28 February 2020

FUTURE
PLANNING AND DEVELOPMENT

Application under Section 73 of the Town and County Planning Act 1990 for variation of Condition 1 of A/81/18/RES at Quiet Waters, Roundstone Lane, Angmering, BN16 4AX

Plots 15-18 external
stairs sections

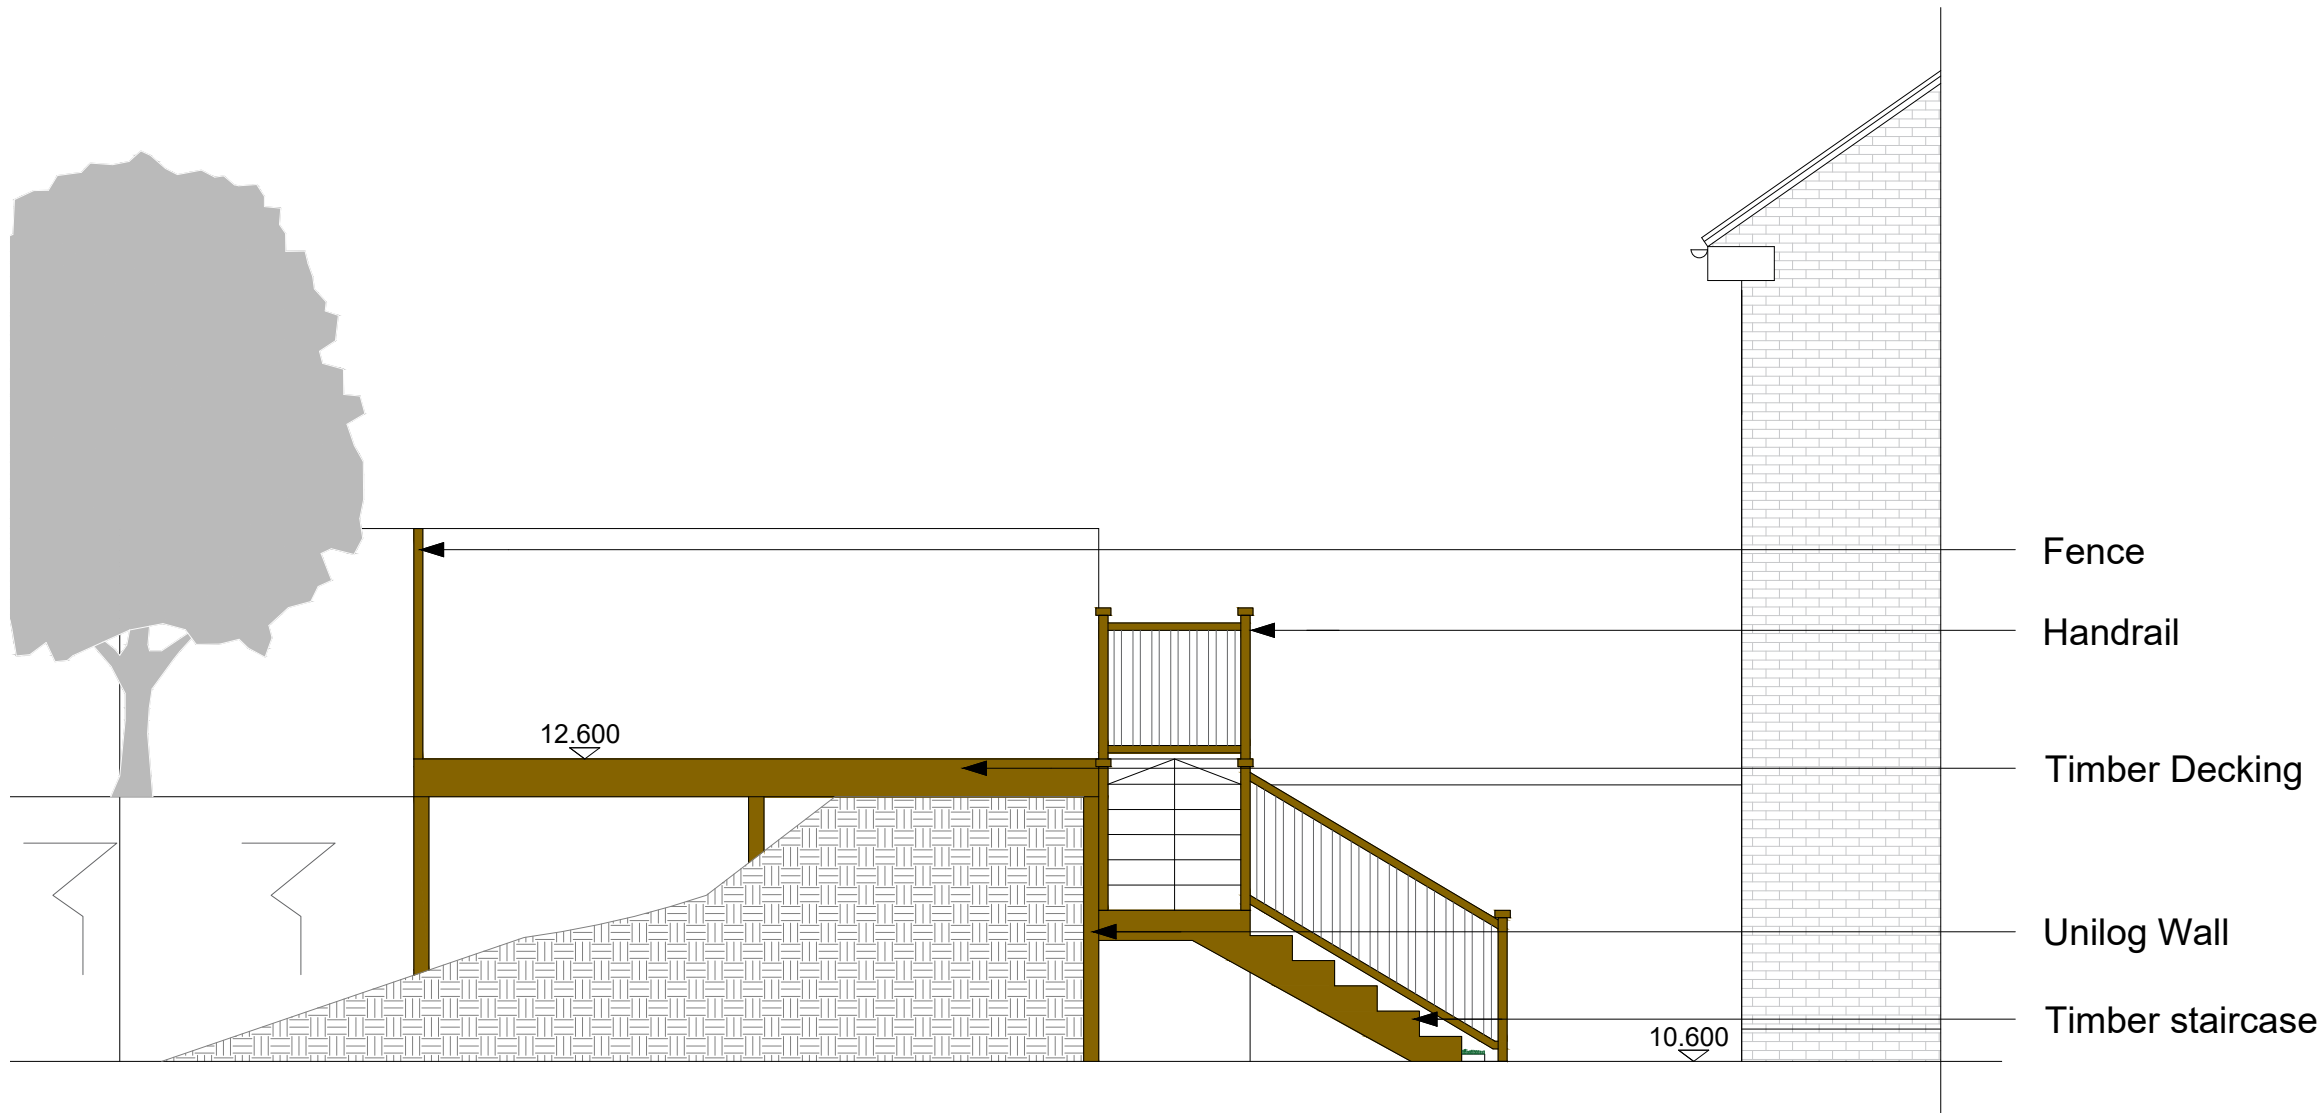
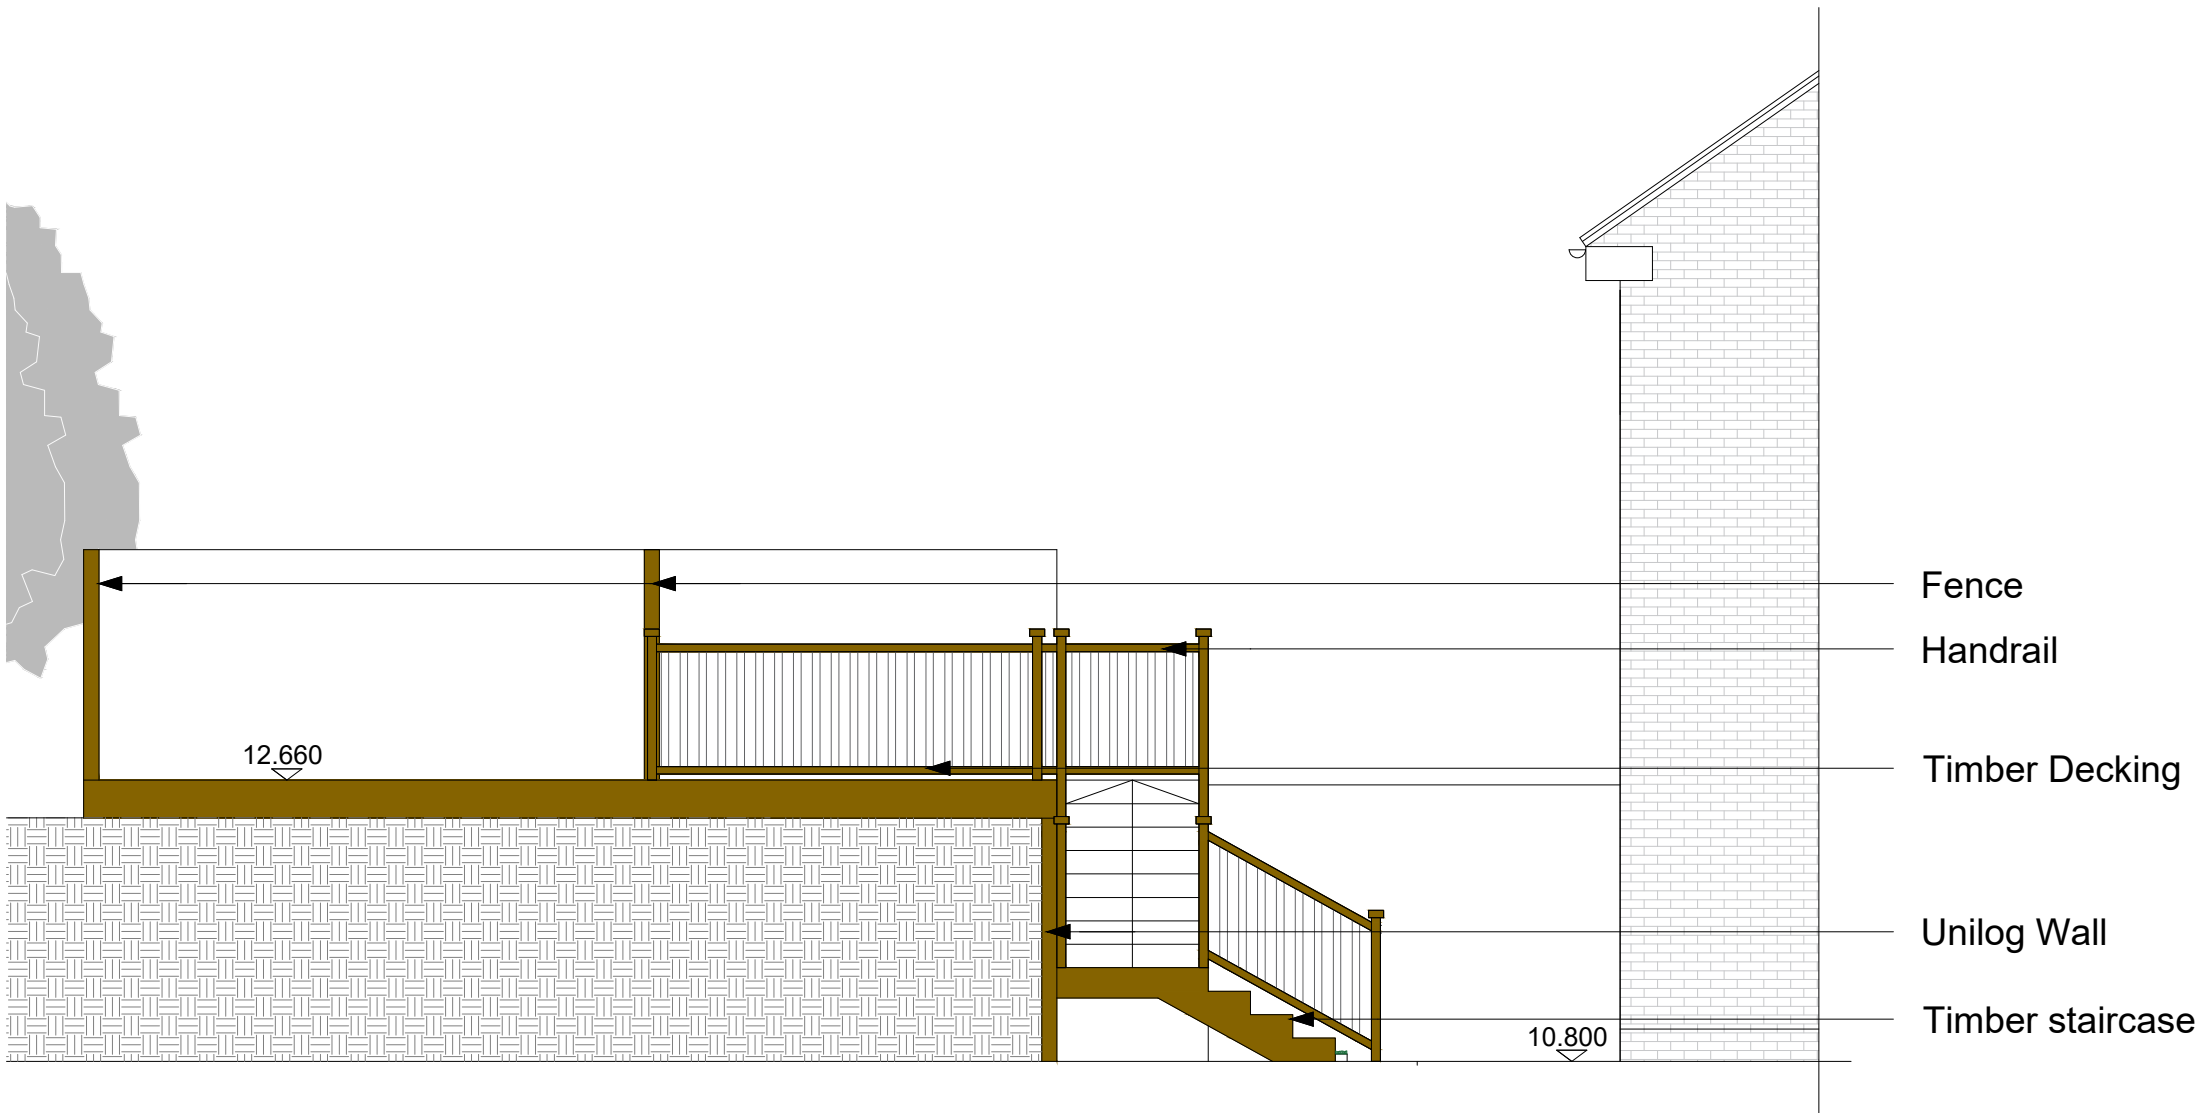
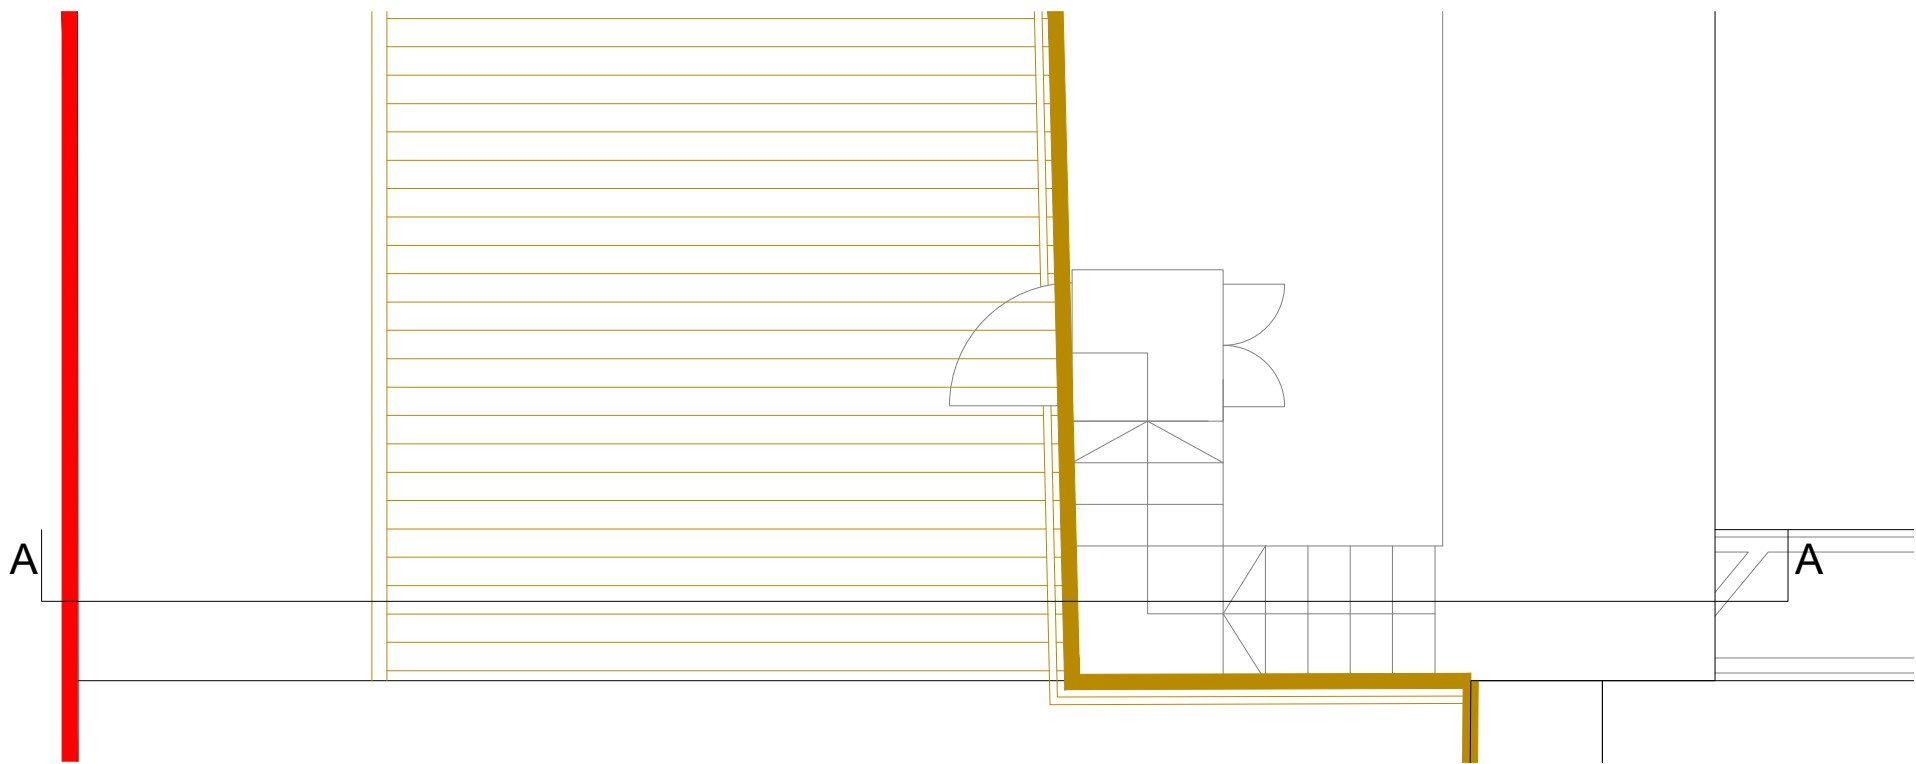
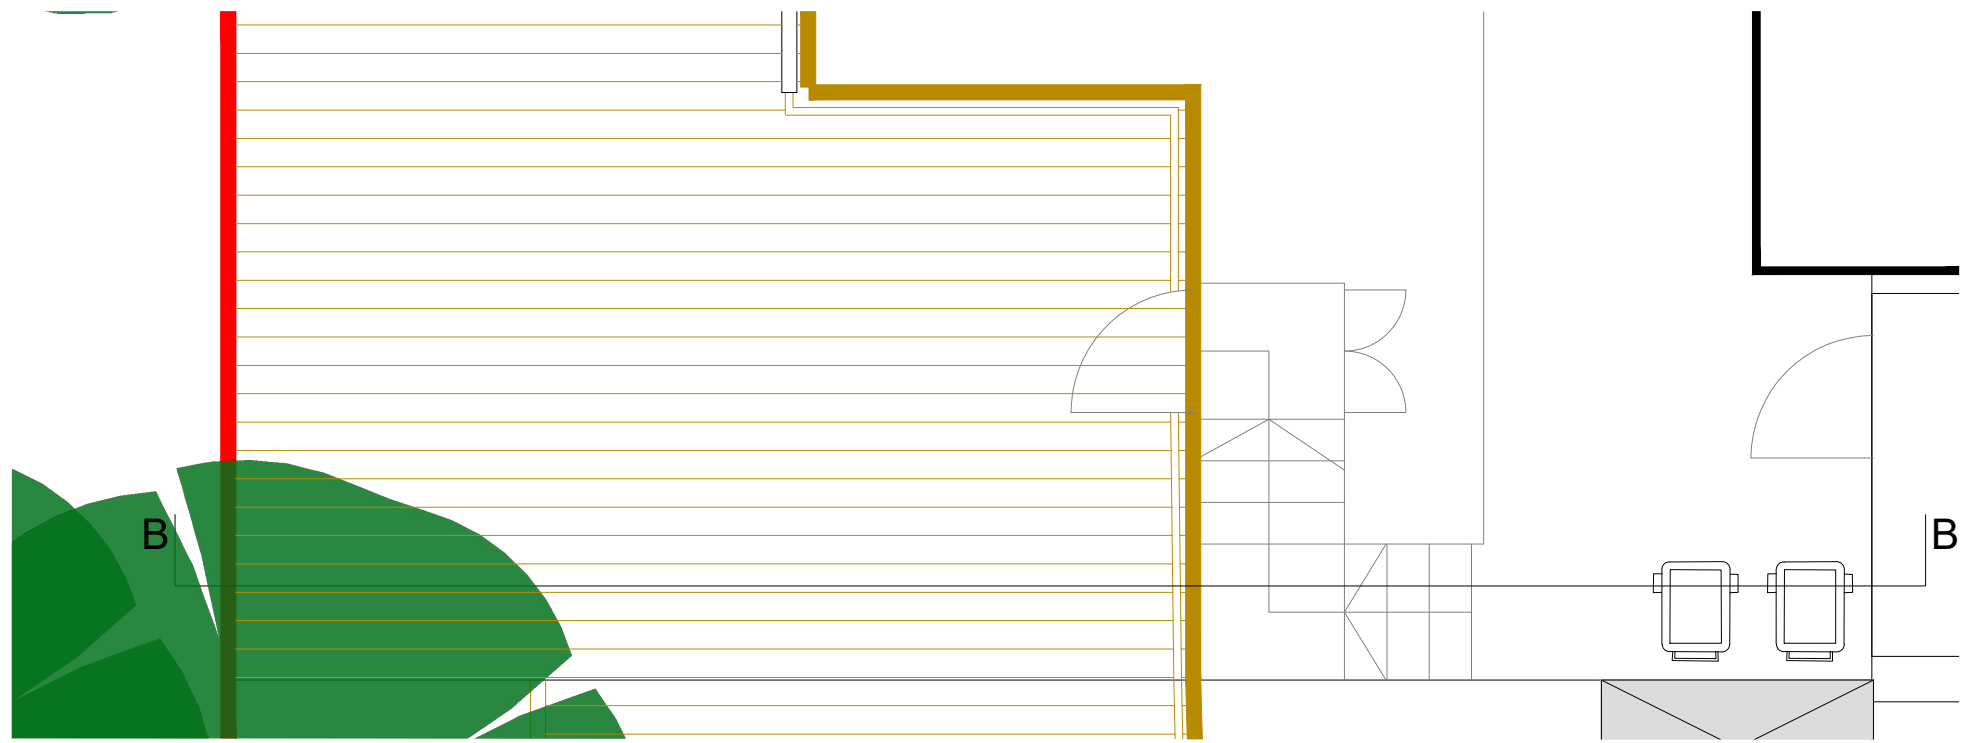
8. **Unilog Wall** – A handrail has been added along the top of the Unilog wall as a safety measure.
9. **Plots 15-18** – Wooden decking proposed to rear of gardens (behind Unilog wall) in order to make this area usable. Lightweight steps provided to the decked area with built-in storage underneath. Paths/patios extended to the position of the steps. Balustrades provided to match the decking style for Plots 15 and 18, with close-board fencing for Plots 16 and 17 to prevent overlooking.

However, the introduction of wooden decking to the rear of Plots 15-18 would constitute a material amendment to the scheme. This specific change is proposed in order to improve the quality of the external amenity space for these units. The approved scheme shows split level gardens, with a lower level at the back of the houses and a higher level behind a Unilog wall, accessed by steps up from the lower level. The rear part of the garden is not level and undulates quite significantly in some parts of the site, limiting its value as an amenity space for the houses. Existing sections through each garden are submitted, which illustrate the deficiencies of these areas as amenity spaces.

It is proposed to create a level area of decking for the rear part of the garden for each of the four plots, 15-18, thereby creating usable amenity space. Plans and sections of the proposed decking areas are shown on drawing 1006-Ang111 A. Given that the decking areas will be at a higher level than the rear gardens adjacent to the houses the proposals have been designed to secure privacy for the properties by reducing inter-visibility between windows and gardens – although the approved scheme already includes split level gardens. Specifically, either 1.8m or 1.5m close boarded fencing is proposed to separate gardens in order to reduce visibility and for Plots 16

and 17, which are semi-detached houses, where the potential for overlooking from the decking areas to the lower level rear gardens and rear windows is greater, 1.5m screens are proposed to prevent direct overlooking.
